The Drax Power (Generating Stations) Order

Applicant's Response to Off-Site Mitigation Strategy Submitted by the Local Authorities

Drax Repower Project

Applicant: DRAX POWER LIMITED
Date: January 2019
Document Ref: 8.4.11
PINS Ref: EN010091

54,779

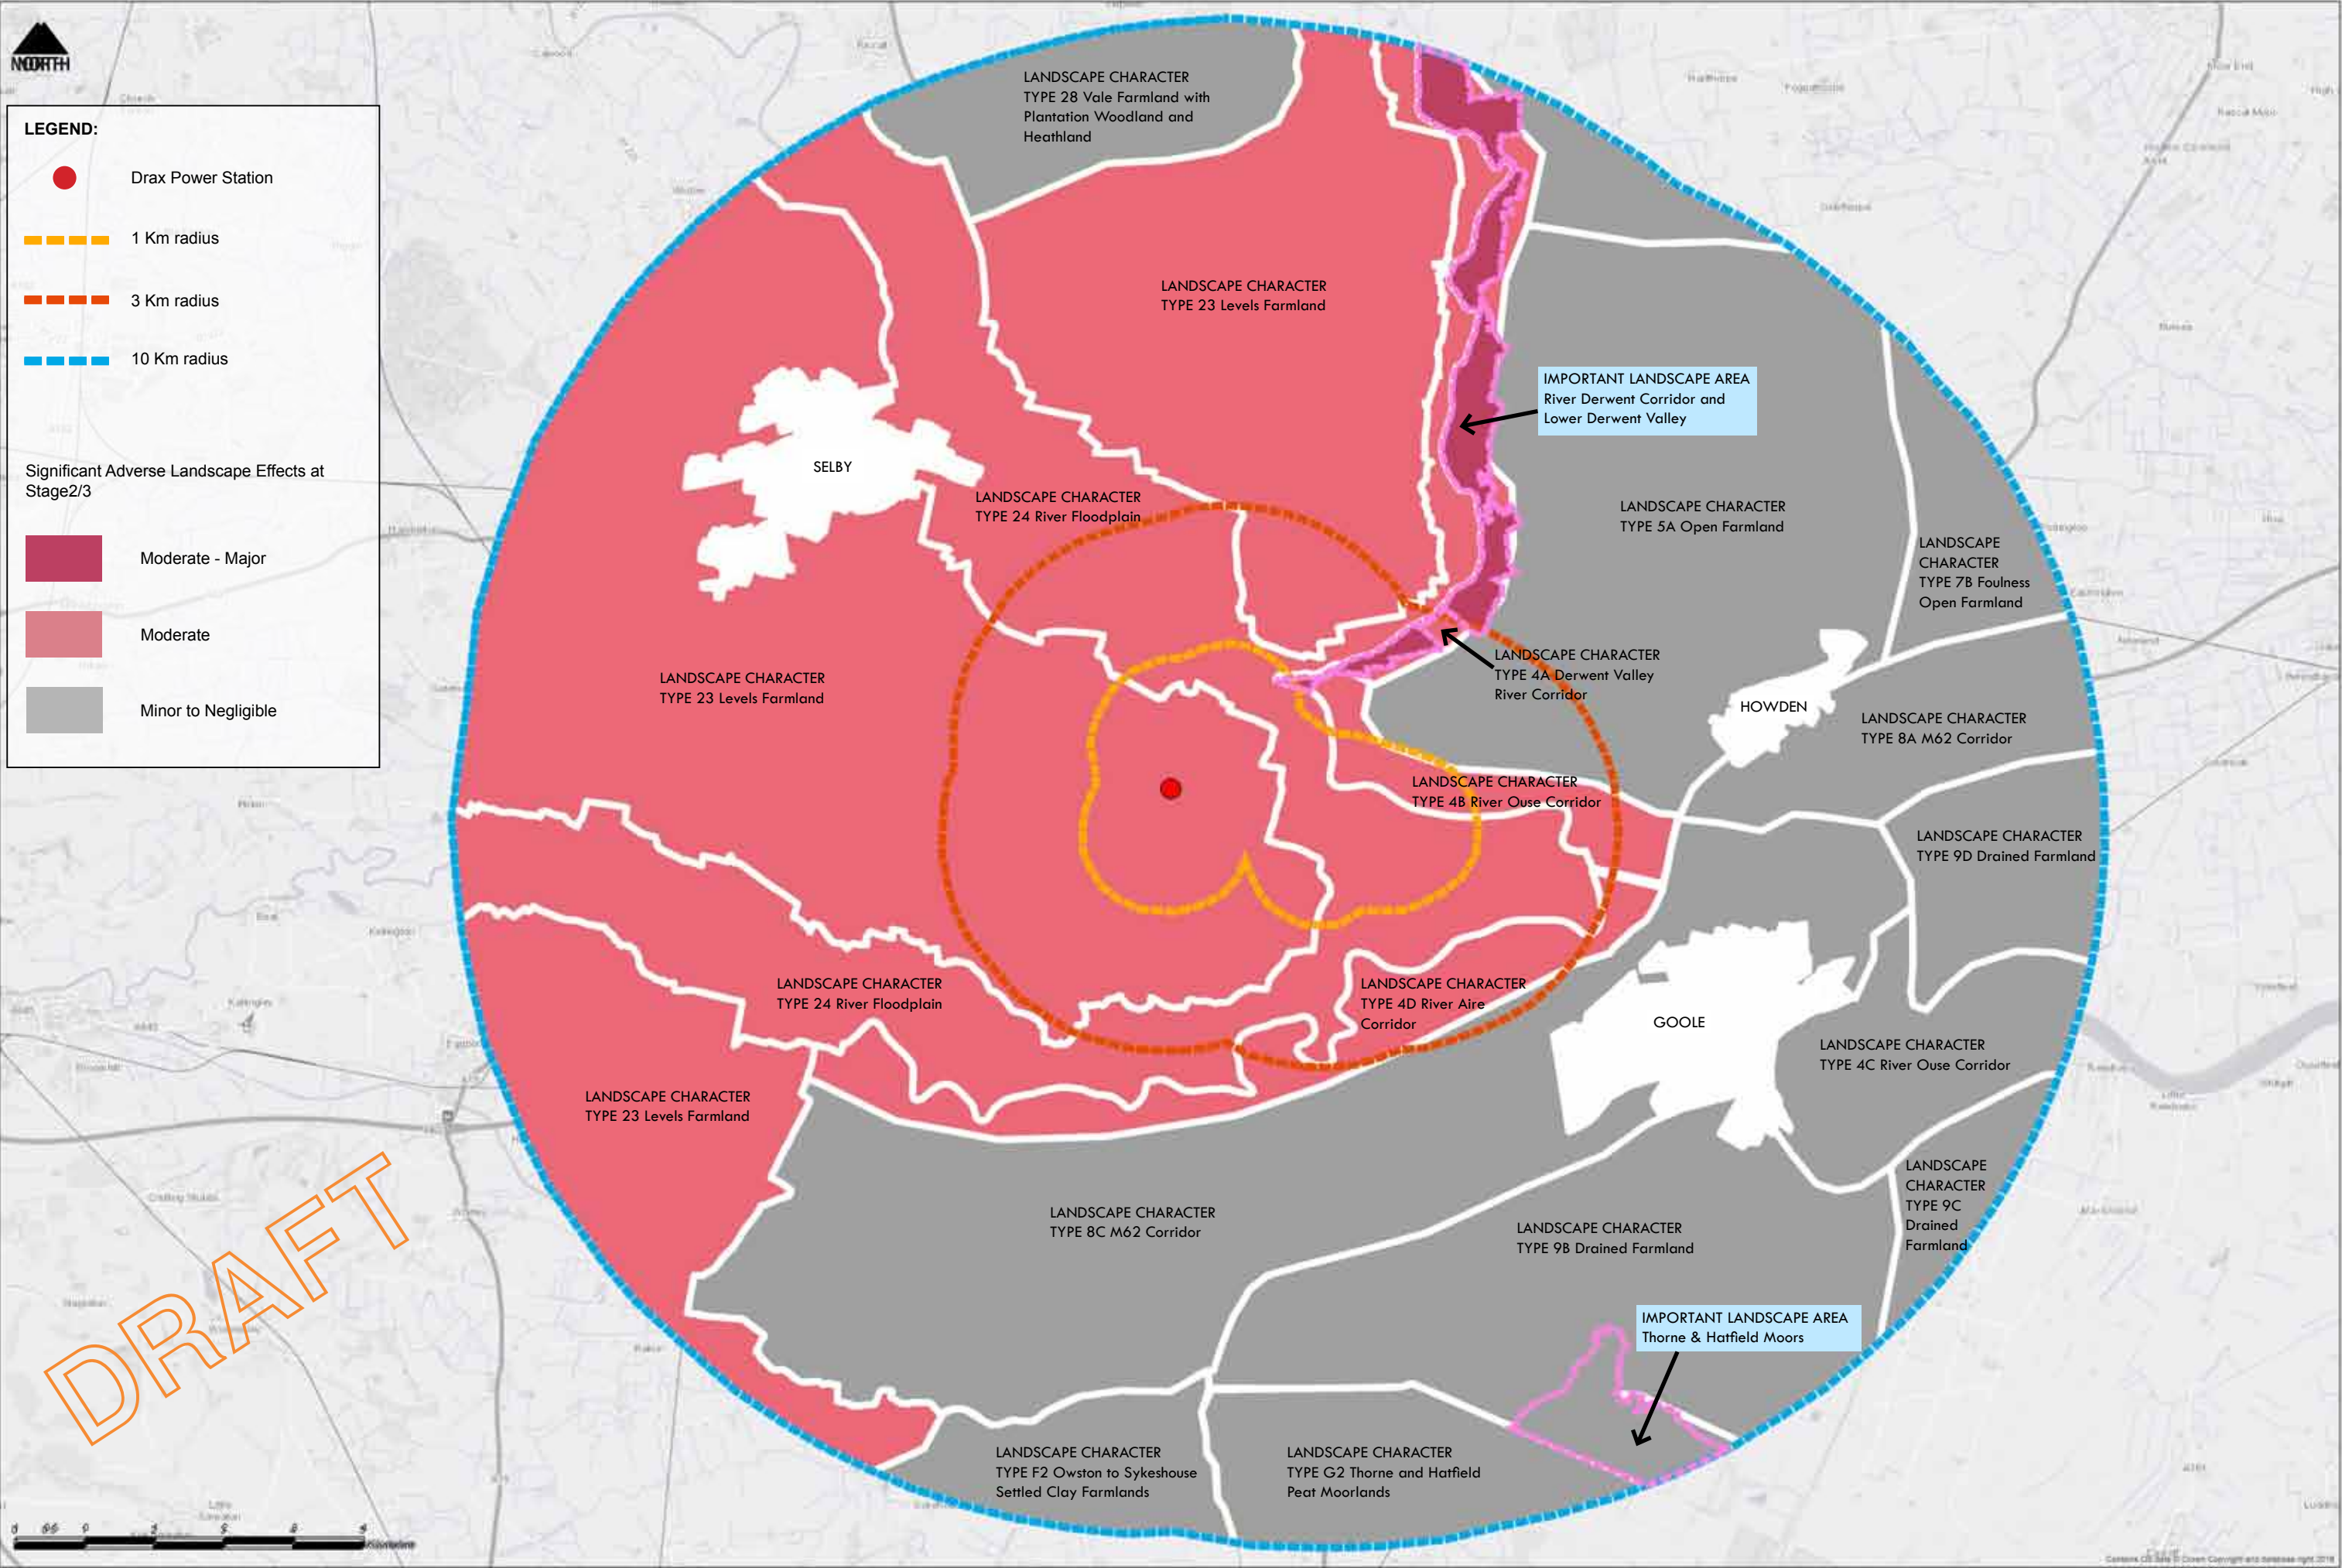
- 2.3.4. The Applicant also disagrees with the presentation of the figures in the OSMS demonstrating the significant effects and covering landscape character and visual effects associated with Public Rights of Way and the Trans Pennine Trail. The figures presented on Pages 4, 5 and 6 of the OSMS provide a "blanket cover" to landscape and visual effects to a distance of 10 km which as outlined above, and in the LVIA, diminish with distance and beyond a 3 km radius. Chapter 10, Landscape and Visual Amenity of the ES makes it very clear that significant effects are based on a "worst case scenario" and there would be effects which are less than the level predicted. Comments relating to each of the figures are summarised in the table below with reference to relevant paragraphs from the ES.

Relevant Figure in the OSMS	Key comments and relevant paragraphs from the ES
Figure on Page 4 illustrates “significant effects on landscape character areas where no off site mitigation / enhancement proposed”	Such effects are based on a “worst case scenario”, and would diminish with distance and beyond a 3 km radius of the Proposed Scheme as outlined in the paragraphs above. Figure on page 4 “reads” as if entire landscape character types defined as moderate – major or moderate adverse would experience significant effects when this is not the case.
Figure on Page 5 illustrates “significant visual effects on Public Rights of Way”.	<p>The LVIA makes it very clear that effects on PRoW are based on a “worst case” scenario and are more noticeable to the northeast, east and southeast of the Existing Drax Power Station Complex and the Proposed Scheme. Effects are dependent on the nature of the view; a direct unfiltered view resulting in a higher level of magnitude of change and therefore significance compared to a view filtered / obscured by intervening built form and vegetation. This is demonstrated in the paragraphs relating to Stage 3 below:</p> <p>Local recreational users within 1 km using the local PRoW network, recreational facilities and sports grounds):</p> <p>Paragraph 10.5.205: <i>“The sensitivity of other recreational users utilising the PRoW network, recreational facilities and sports grounds is medium. Based on a <u>worst case direct and unfiltered view</u> experienced by users within 1 km of the Site, the magnitude of change prior to mitigation would be large to medium. Therefore, there is likely to be a direct, long term effect on immediate residential receptors of moderate - major and moderate adverse significance prior to the implementation of secondary mitigation measures.”</i></p> <p>Paragraph 10.5.206: <i>“A proportion of other recreational receptors within 1 km have partial screening by other development or vegetation or are oriented away from the site. For these, the magnitude of change would <u>vary from small to negligible resulting in a direct, long term effect of minor adverse to negligible adverse significance</u> prior to the implementation of secondary mitigation measures. Such effects are not considered significant.”</i></p> <p>Local recreational users between 1 and 3 km using the local PRoW network, recreational facilities and sports grounds:</p>

Relevant Figure in the OSMS	Key comments and relevant paragraphs from the ES
	<p>Paragraph 10.5.208: <i>“The sensitivity of other recreational users utilising the PRow network, recreational facilities and sports grounds and who would experience a direct view is considered to be medium. Based on a <u>worst case view</u>, the magnitude of change prior to mitigation experienced by such users between 1 & 3 km of the Site who have a direct and unfiltered view is medium. Therefore, there is likely to be a direct, long term effect on recreational users of moderate adverse prior to the implementation of mitigation measure and this is considered a significant effect. As above remaining recreational users would experience a range of effects from minor adverse to negligible adverse significance prior to the implementation of secondary mitigation measures.”</i></p>
<p>Figure on Page 6 illustrates “significant visual effects on Trans Pennine Trail”.</p>	<p>The LVIA makes it very clear that effects on the Trans Pennine Trail are based on a “worst case” scenario and that effects would be based on a direct, unfiltered view as demonstrated in the following paragraphs relating to Stage 3:</p> <p>Local recreational users within 1 km of the Site:</p> <p>Paragraph 10.5.204: <i>“The sensitivity of recreational users using the TPT and NCN to the north of the River Ouse is high. Based on a worst case direct and unfiltered view the change arising from Stage 3 would be of medium magnitude. This would give rise to a direct, long term moderate – major adverse significant effect on recreational users of the TPT and NCN prior to the implementation of secondary mitigation measures.”</i></p> <p>Local recreational users between 1 and 3 km of the Site:</p> <p>Paragraph 10.5.207 <i>“The sensitivity of recreational users on the TPT and NCN to the north of the River Ouse is considered to be high. Based on worst case views, the change arising from Stage 3 would be of medium magnitude. This would give rise to a direct, long term moderate - major adverse significant effect on recreational users of the TPT and NCN prior to the implementation of secondary mitigation measures.”</i></p> <p>In addition, the Applicant questions why the entire 1 and 3 km radius for the figure on Page 6 is shown as significant when effects solely relate to 1 and 3 km distances from the Trans Pennine Trail and considers the figure has</p>

Relevant Figure in the OSMS	Key comments and relevant paragraphs from the ES
	overexaggerated the extent of effects visually.
